**Re: ABB ABQ Expansion – 6625 Bluewater Rd NW
Erosion and Sediment Control Plan
Engineer's Stamp Date – 12/7/2023 (K10E011)**

Based upon the information provided in your submittal received 12/8/2023, the above referenced ESC Plan can't be approved until the following comments have been addressed.

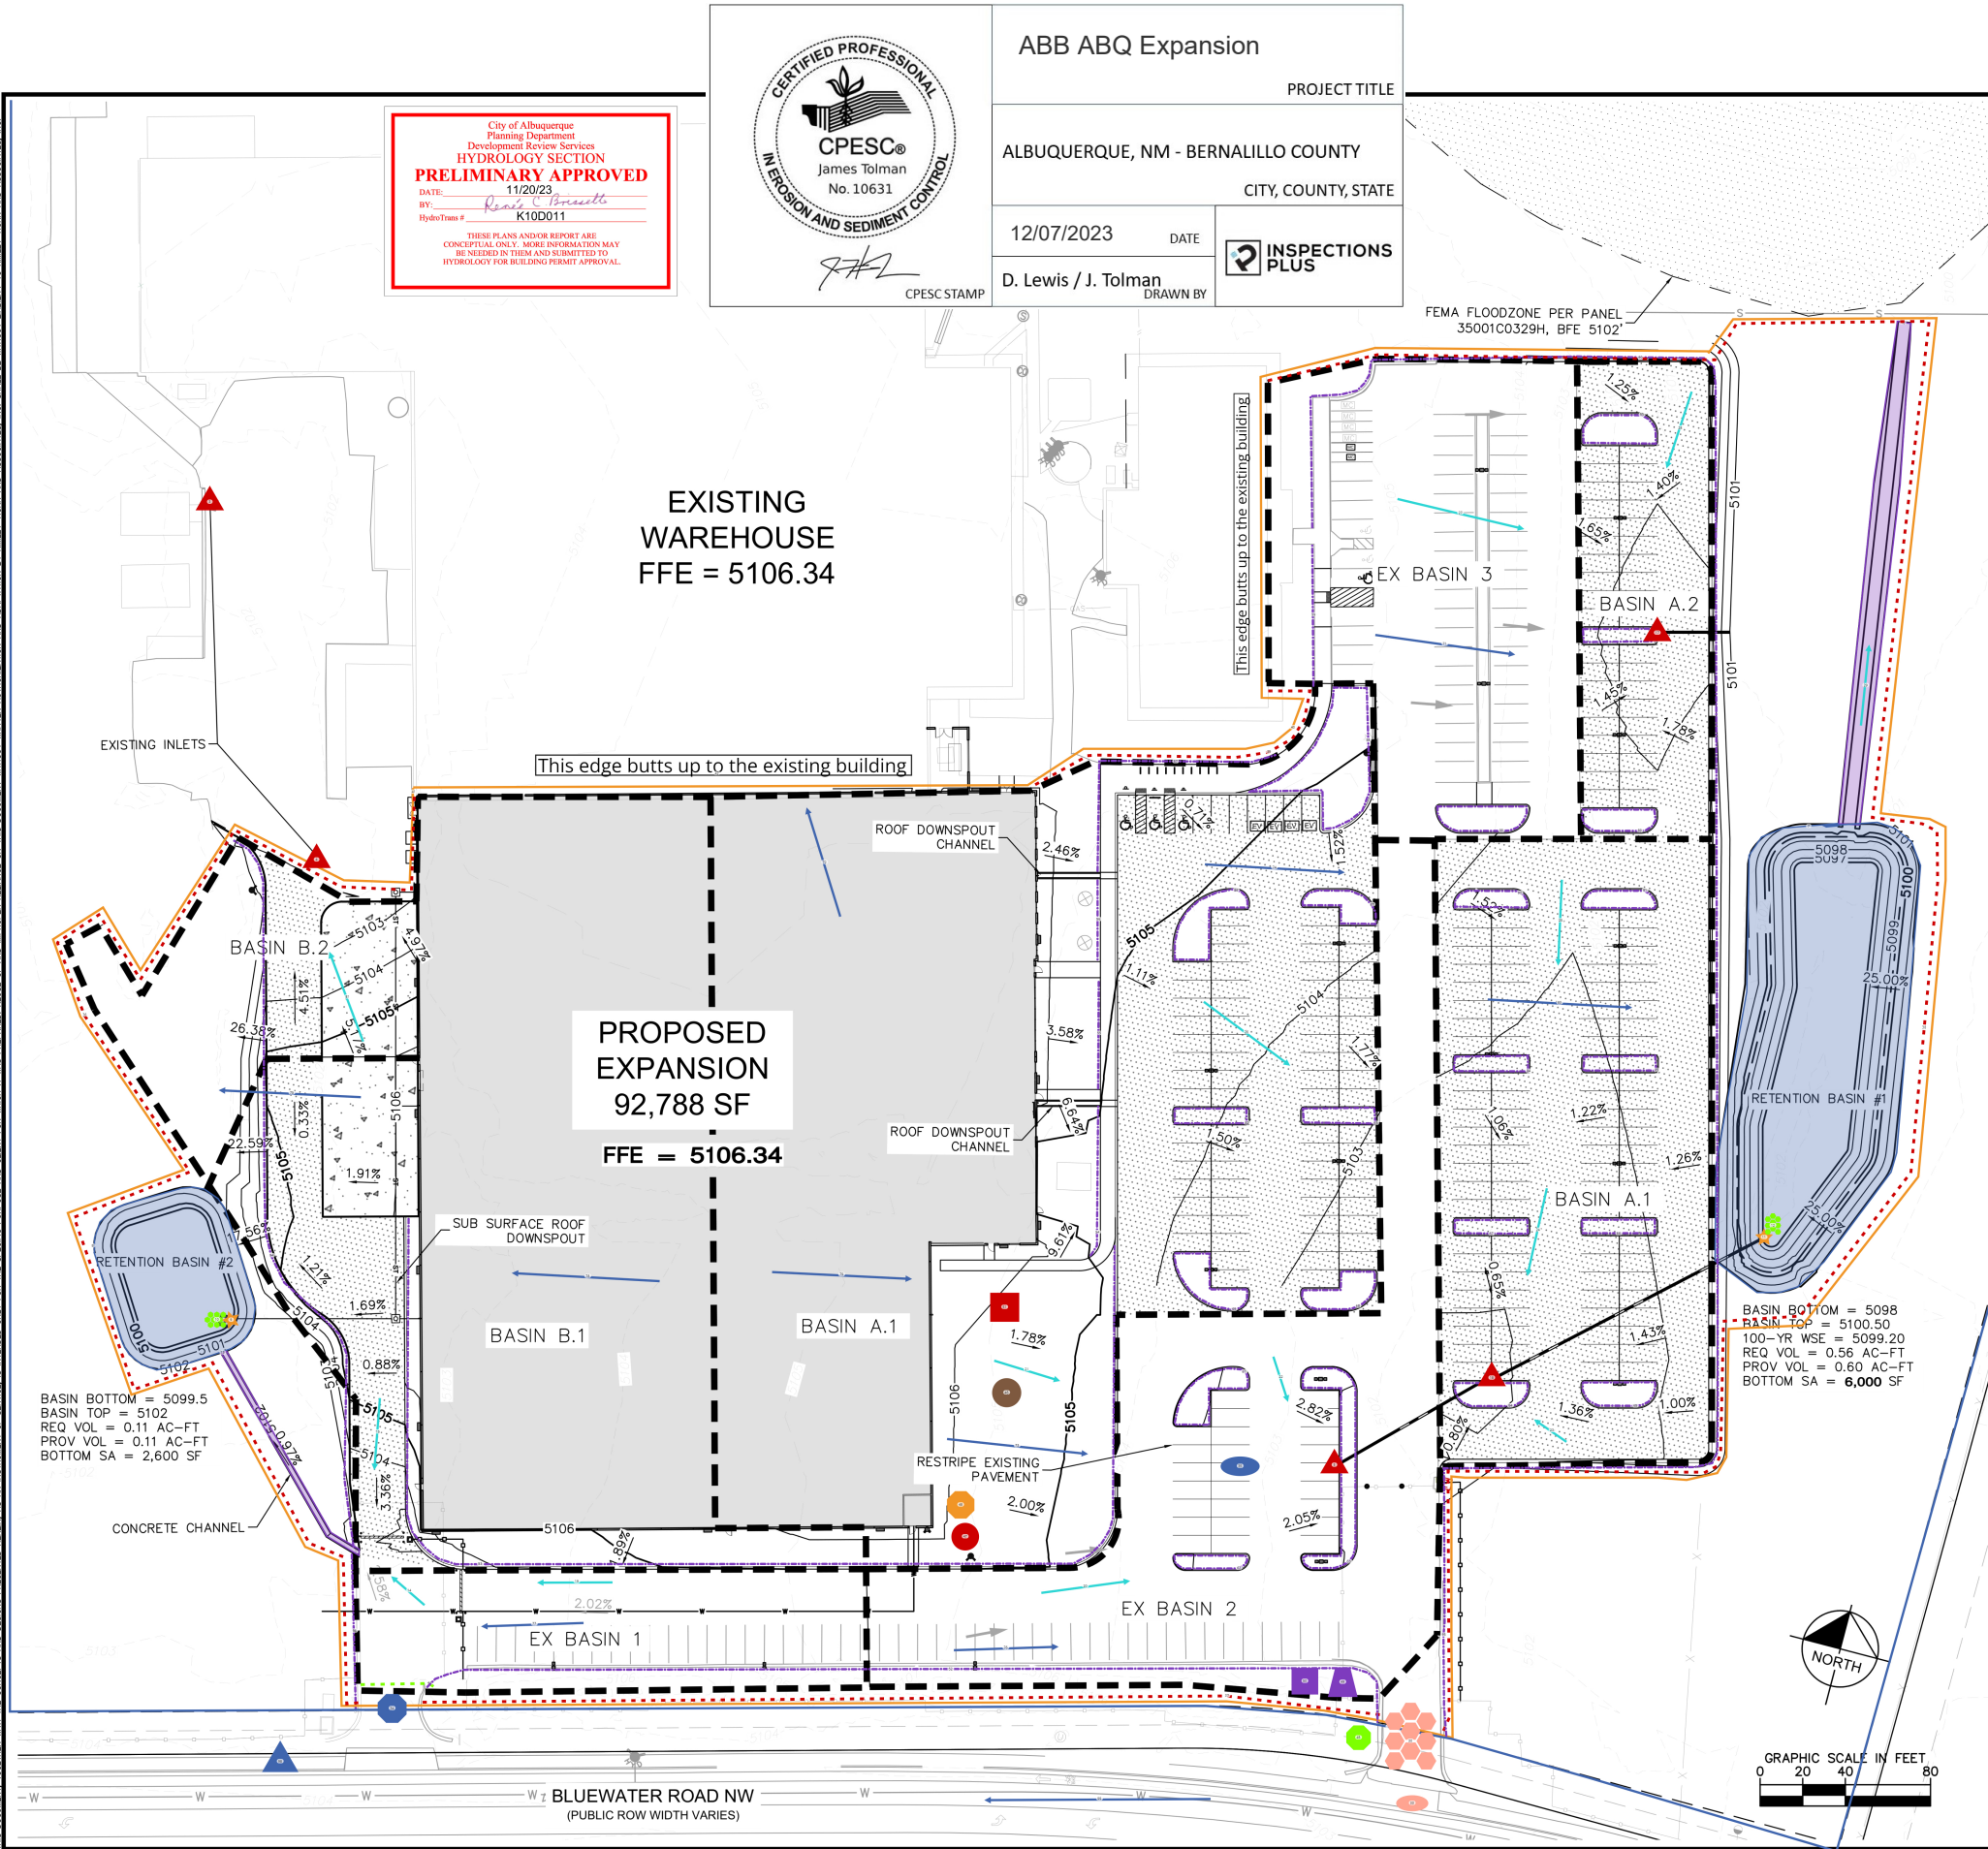
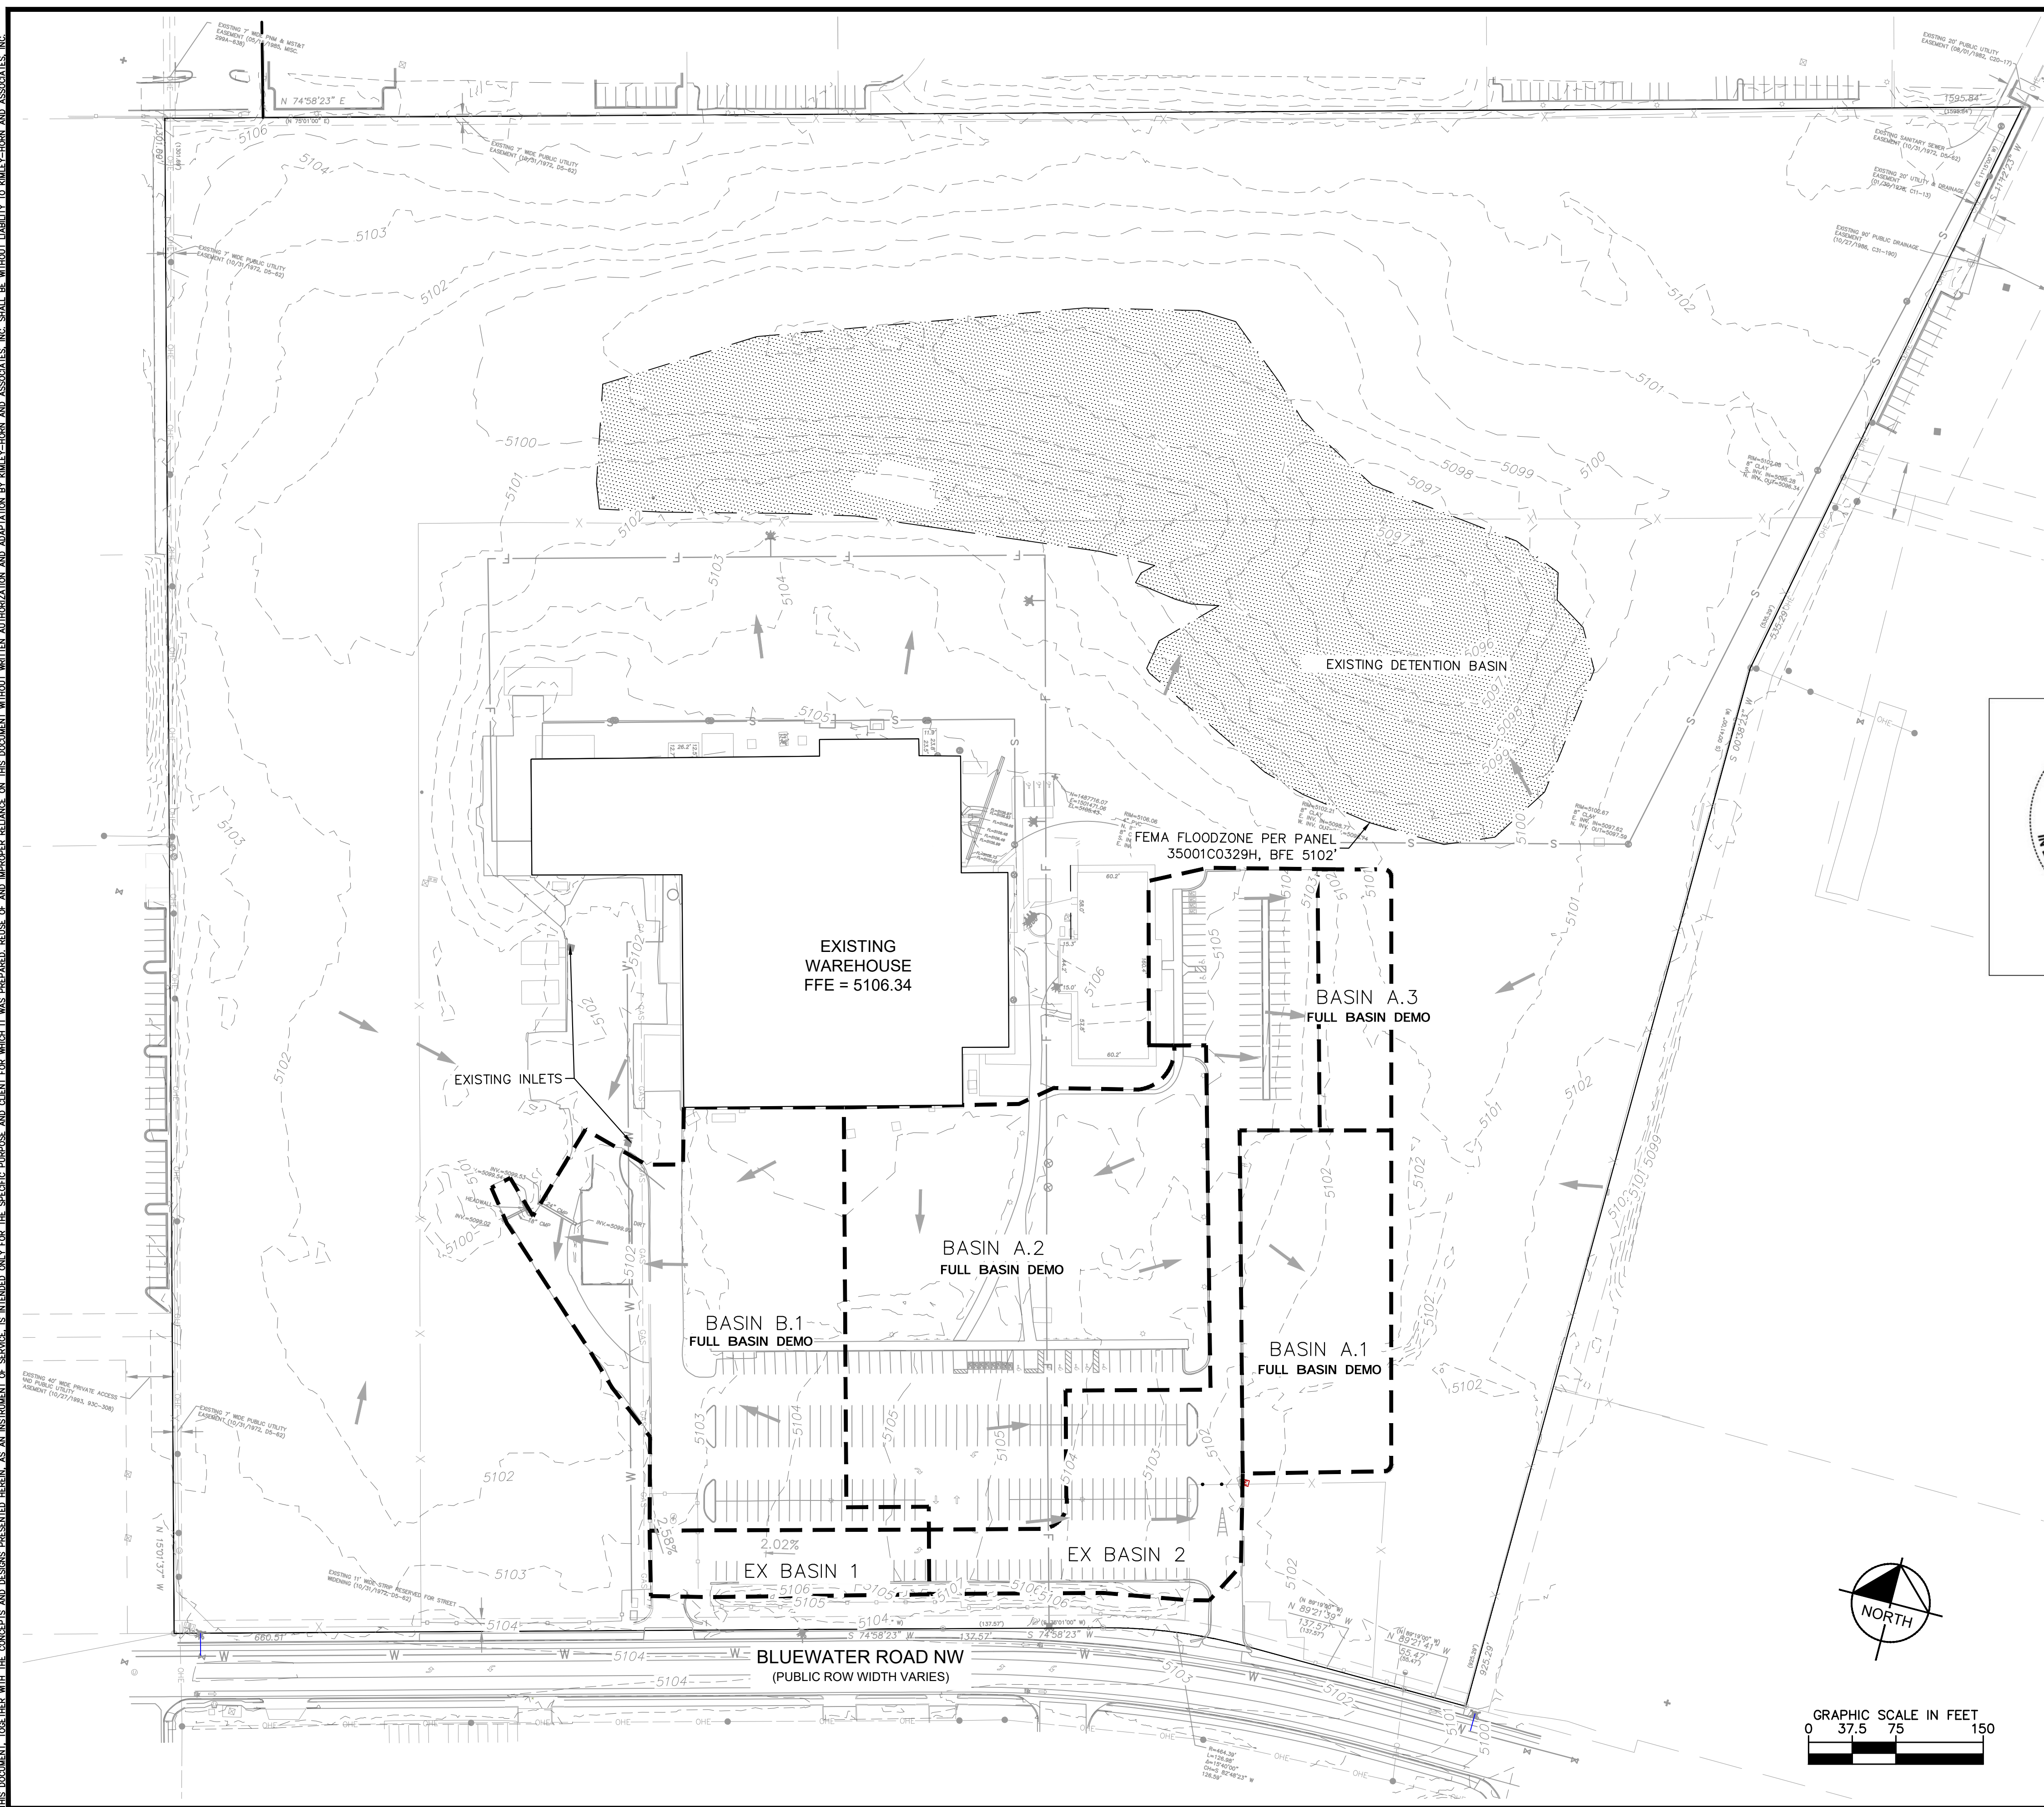
1. The owner information, ABB, Installation Products Inc., as shown on the ESC Plan, Information Sheet, and the NPDES documentation does not agree with the available Bernalillo County records which show Amerace Corporation as the property owner. Property rights may have changed hands recently, if so, please provide documentation in the form of a recorded deed or lease. The accurate name and contact information for the entity in control of the property rights is required on the Information Sheet, the NPDES documentation, the SWPPP, and the ESC Plan.

3. Temporary sediment basins and/or sediment traps are required for sites 5 acres or larger, and for sites that are part of a Common Plan of Development that is 5 acres or larger per DPM Part 6-14(D) and CGP 2.2.12. The first flush ponds approved by Hydrology on the Grading and Drainage plans are designed for a much smaller volume than that required by CGP 2.2.12, so larger temporary sediment ponds must be provided during construction (The calculated volume of runoff from a 2-year, 24-hour storm; or 3,600 cubic feet per acre drained). The ESC Plan must include dimensions of the temporary sediment ponds, details of the embankment and overflow structures with volume and hydraulic design calculations, construction specifications, maintenance schedules, and criteria for inspections, per CGP 9.6.1(C)(i). Include a narrative description of the conditions that must exist prior to the removal of the temporary pond and the procedure for converting the area to the final stabilized condition.

5. The ESC Plan submitted includes an older version of the ESC Plan Standard Notes. The current Plan Standard notes are attached.
6. Update the engineer's stamp date each time the plan is changed.
